Your Ref: MP09_0088
Our Ref: S13/0014
DA13042487237 JM

4 June 2013

Exhibition of Environmental Assessment for Concept Plan Approval – Mixed Use Subdivision, West Culburra (MP09-0088)

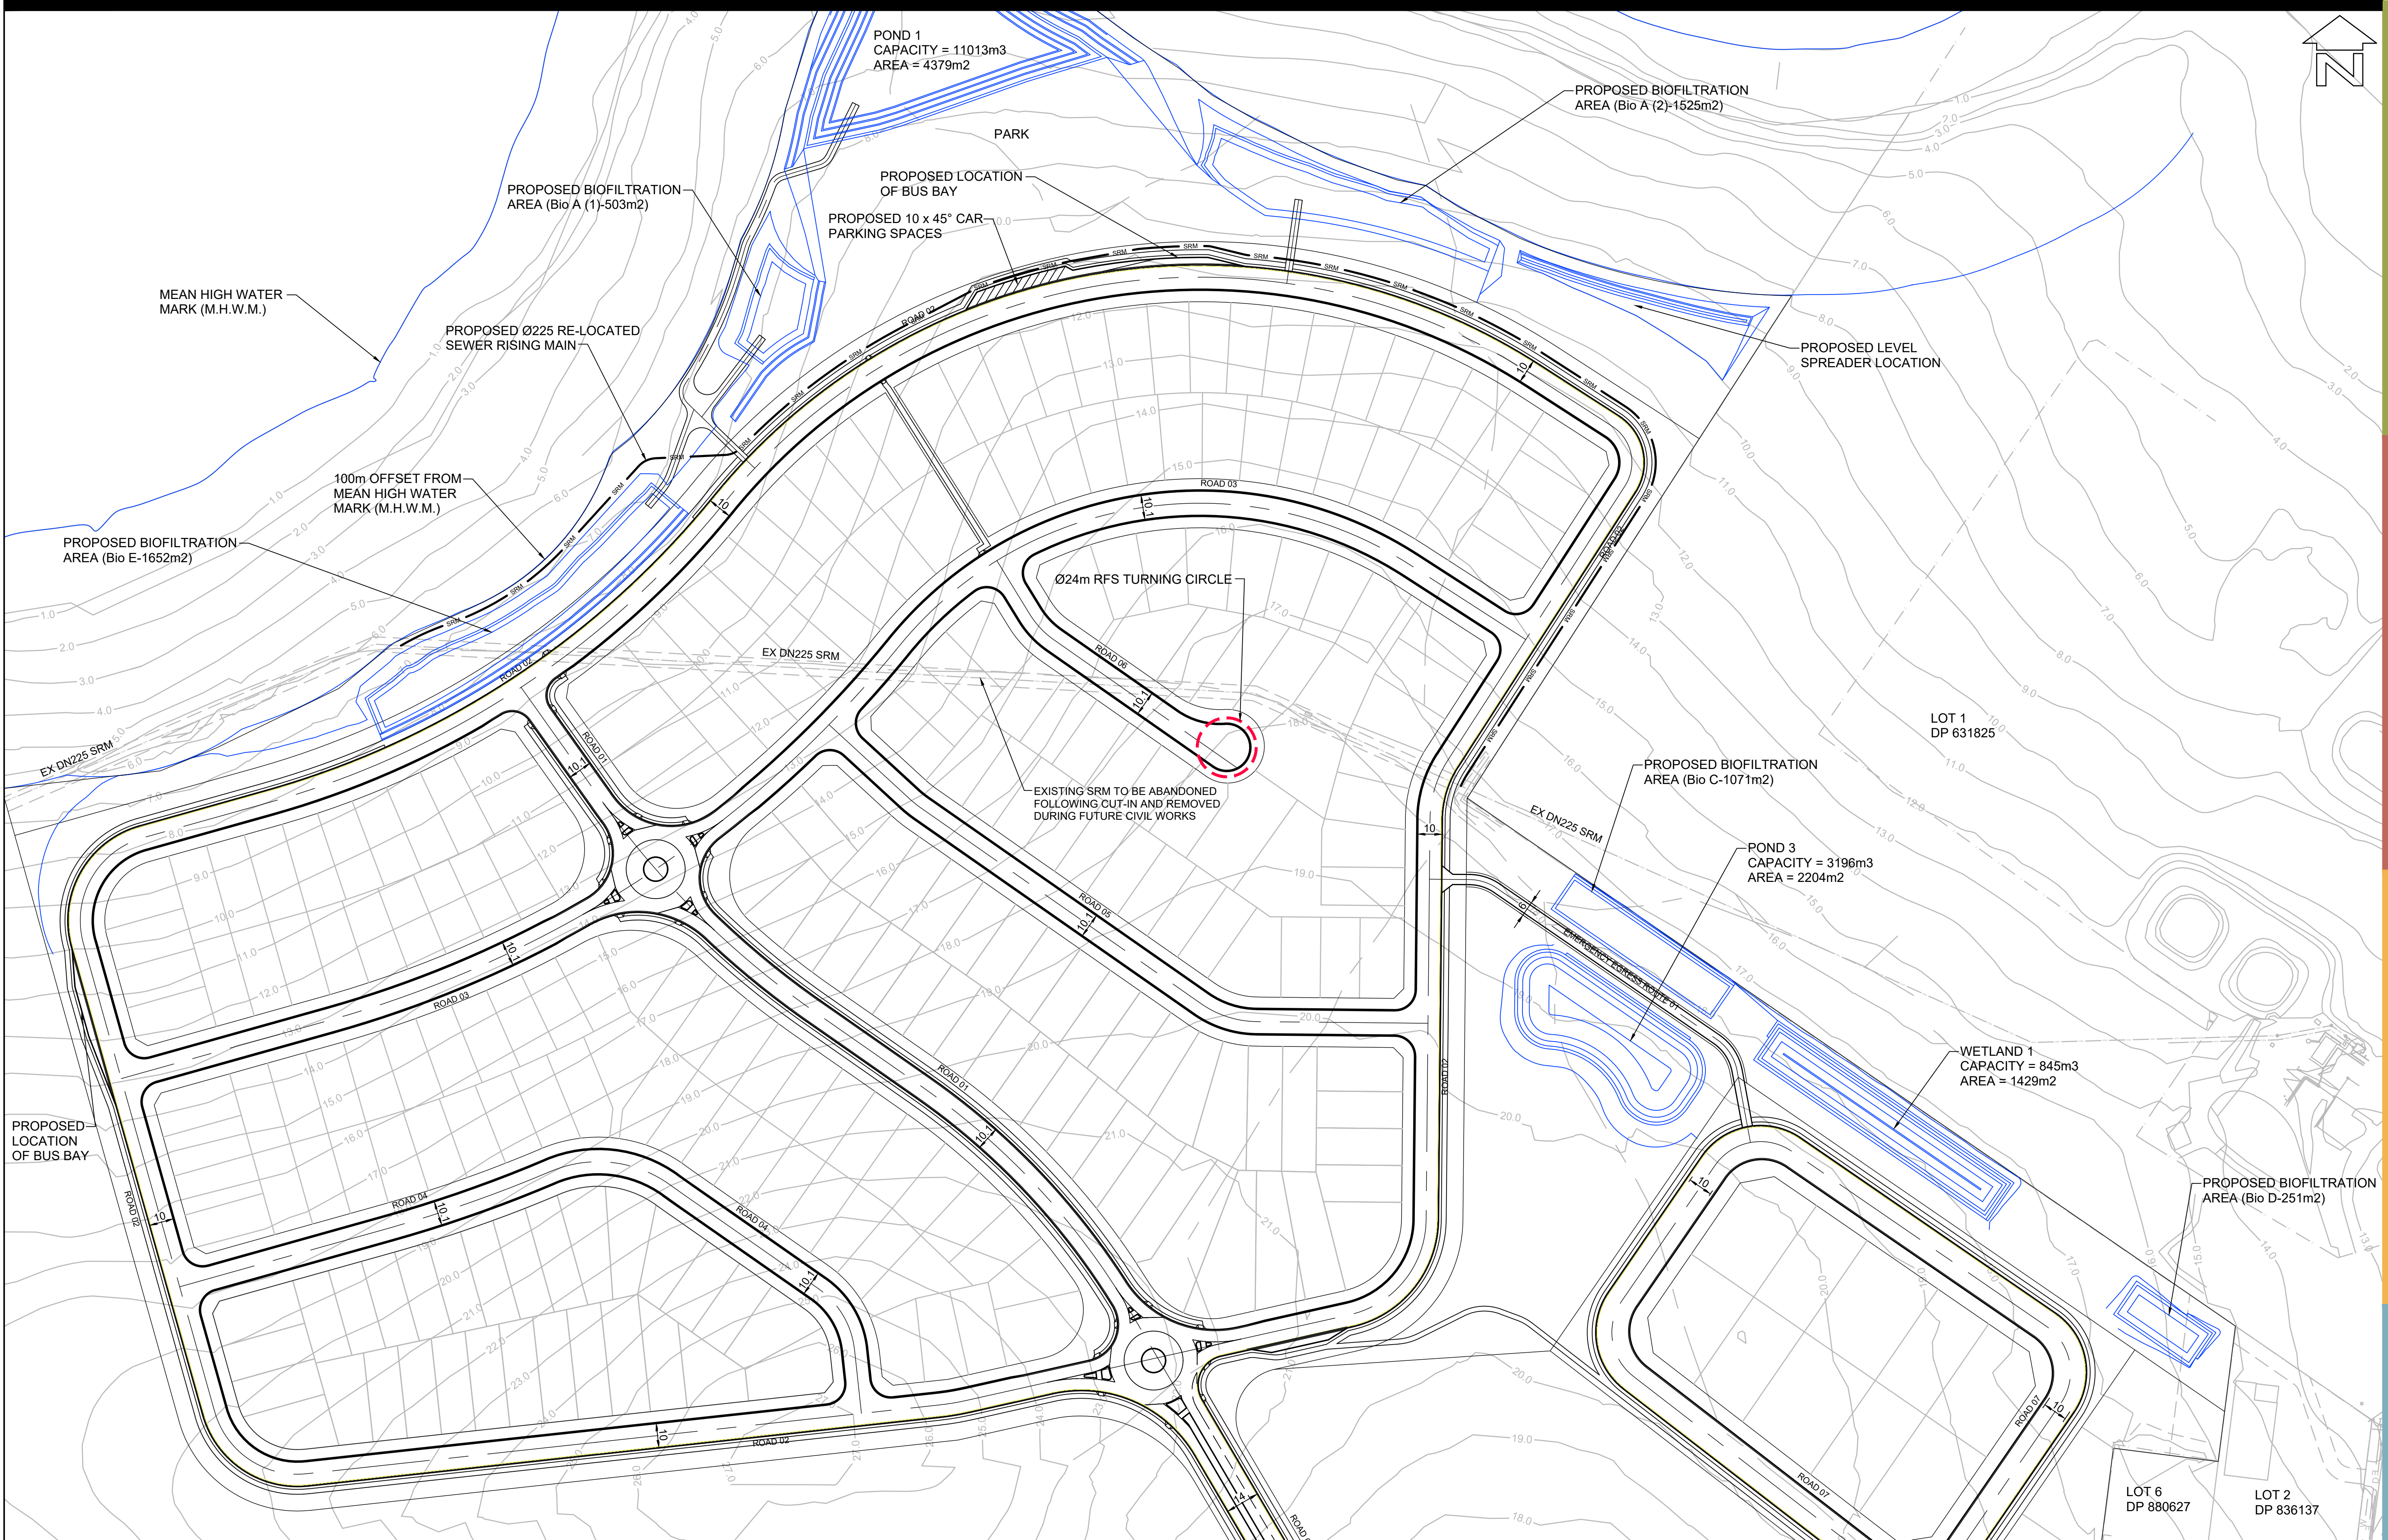
Stage 1 – residential subdivision (21 x 2br 55+ single story villas (SFPP); 48 x 2br units)

APZ of 25m provided on the south and south west elevations. APZ of 20m on the north west boundary. Culburra Rd to the north and existing retirement village to the east. There is a discrepancy in the location of development in this stage between the concept plan map and the bush fire assessment map in the Eco Logical Australia report. APZs meet requirements of PBP table A2.4 for non SFPP development.

The SFPP component of the stage proposes APZs of 20m and 25m (east) and 25m (south). It is unclear where the SFPP component of this stage (55+ age group housing) is located. The boundary of stage 1 and therefore the APZ configuration differs between the concept plan (Allen Price Associates) with APZs and the APZ map in the Eco Logical Australia report. To ensure compliance with the requirements of PBP for SFPP development, specifically less than 10kW/m² radiant heat exposure, no part of the 55+ age group housing can be closer than 70 metres to the bush fire hazard (ie 70m APZ or 55+ housing located 70m away from the stage boundary).

Stage 2 – residential subdivision (single house lots, small residential lots, tourist site (T3 – to be used as a Cafe – not SFPP))

APZs include the Culburra Rd to the south, 20m to the south east, 25m to the east toward the sewage treatment plant (as a fire trail) and 25m to the north / north west. These APZs meet requirements of PBP table A2.4.

Tourist site, T3 (Cafe), has an APZ proposed of 10m. The proposed 10m APZ for "defendable space only" would result in any development on the site being exposed to a high bush fire attack level. Given the site is identified as a future tourist use, consideration should be given to an adequate APZ that reflects the vulnerability of the users. Alternatively resighting of the T3 precinct further toward the south east which would enable a continuous 25m APZ around the perimeter of the development may be appropriate.

Stage 3 – residential subdivision (single house lots and medium density site – including 26 x 2br 55+ single storey villas (SFPP))

APZs are 25m to the north and south of the stage, meeting the requirements of PBP table A2.4. The 25m APZ on the southern elevation of the medium density site is located outside the proposed property boundary, which would necessitate a section 88B instrument on the adjoining landowner, and clearing in the Lake Wollumboola catchment. PBP requires that APZs are wholly located within the boundaries of the development unless exceptional circumstances apply in accordance with Clause 3.3 of PBP. Currently it is not clear what exceptional circumstances apply. This is not supported, as all APZs should be contained within property boundaries.

The SFPP component of the stage proposes APZs of 25m to the south. It is unclear where the SFPP component of this stage (55+ age group housing) is located. To ensure compliance with the requirements of PBP for SFPP development, specifically less than 10kW/m² radiant heat exposure, no part of the 55+ age group housing can be closer than 70 metres to the bush fire hazard (ie 70m APZ or 55+ housing located 70m away from the stage boundary). The APZ to the south of this component of this stage is not contained within the stage boundary but pushes into the Lake Wollumboola catchment. The APZ should be located within the stage (property) boundary.

The medium density component of stage 3 is shown as having a perimeter rd in figure 3 of the bush fire assessment report, but not in the Allen Price Concept Plan. This perimeter should be provided.

APZs be maintained around the perimeter of the development, within the property boundaries as proposed with the following exceptions:

- T3 to be provided with a 25m APZ;
- North eastern elevation of stage 5 (industrial) be provided with a 25m APZ;
- APZs around the medium density developments in stages 1 and 3 be revised depending upon the location of the 55+ age group developments to ensure all 55+ age group housing is located at least 70m away from bush fire hazard to ensure radiant heat levels are no greater than 10kW/m^2 ; and
- Community areas adjacent to lots within 25 metres of lots to be maintained as IPAs.

- To ensure the intent of this measure is met, a second point of access to Culburra Rd be provided.
- A perimeter rd be provided around the medium density component of Stage 3.

PRELIMINARY INDUSTRIAL PRECINCT LAYOUT PLAN

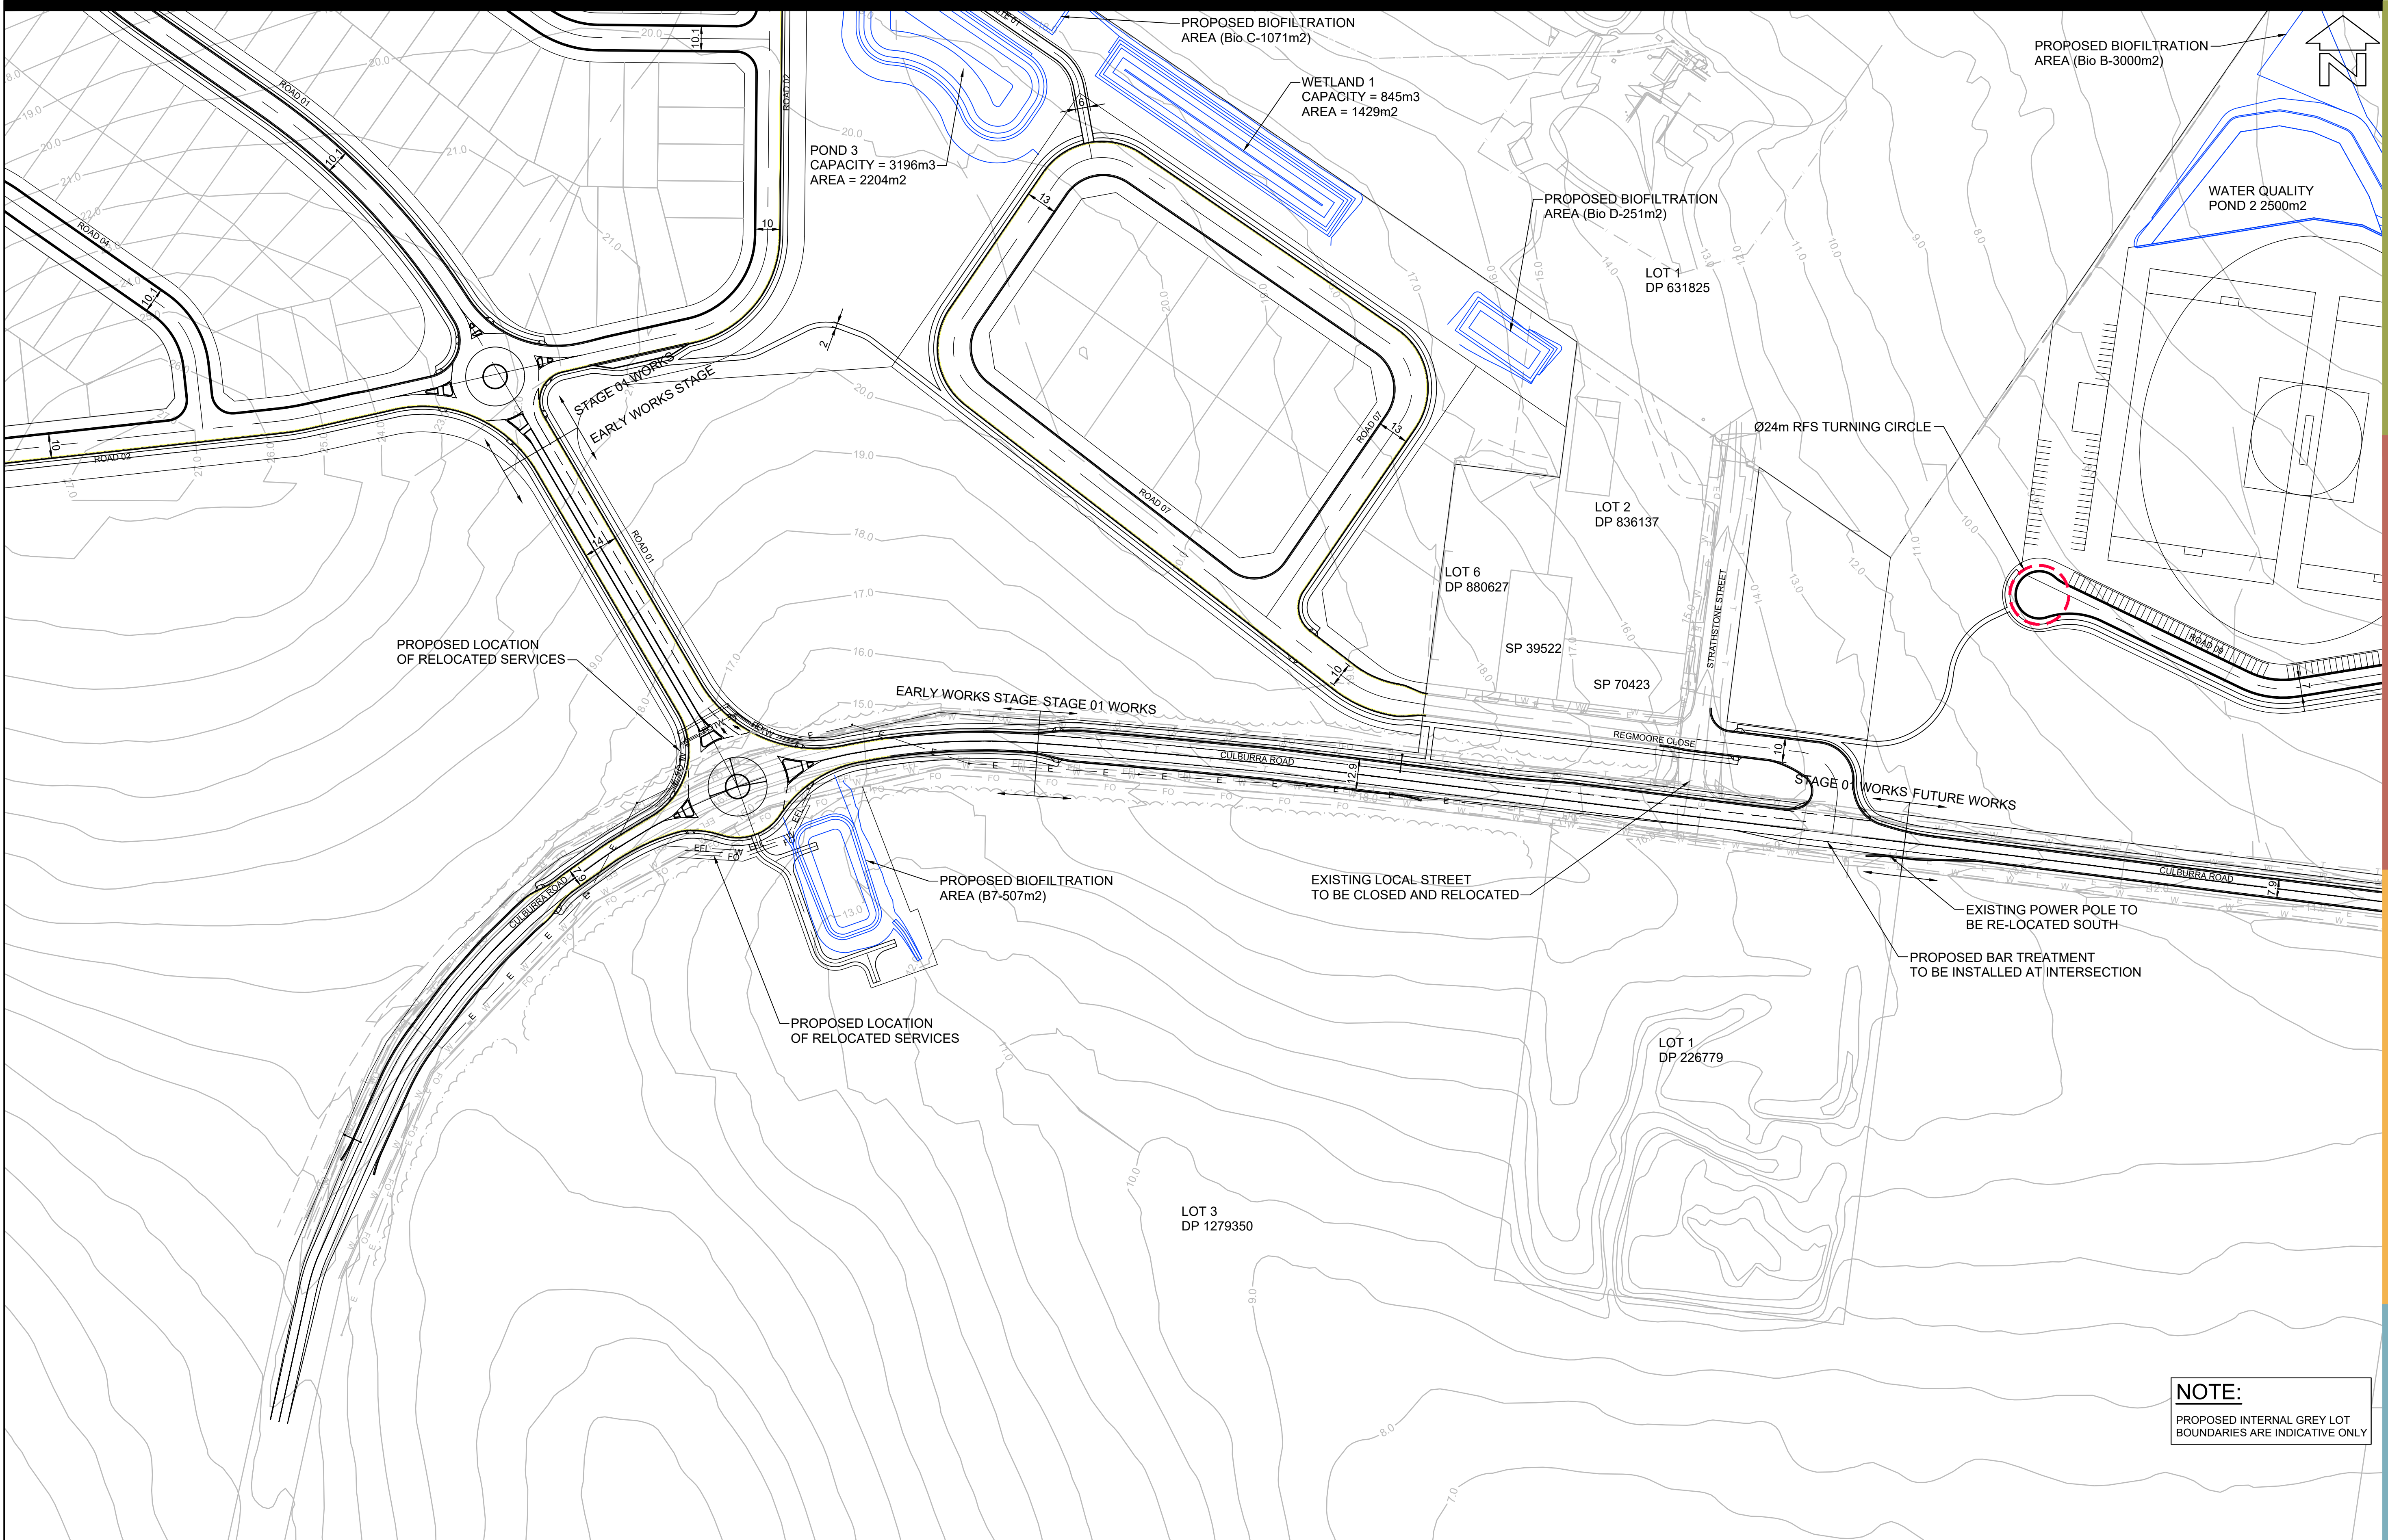
Stage 5 – industrial development (28 x industrial lots)

The perimeter of stage 5 has a 20m APZ proposed, with a fire trail on the north eastern elevation. The north eastern elevation requires a 25m APZ to comply with the requirements of PBP table A2.4, not 20m as proposed.
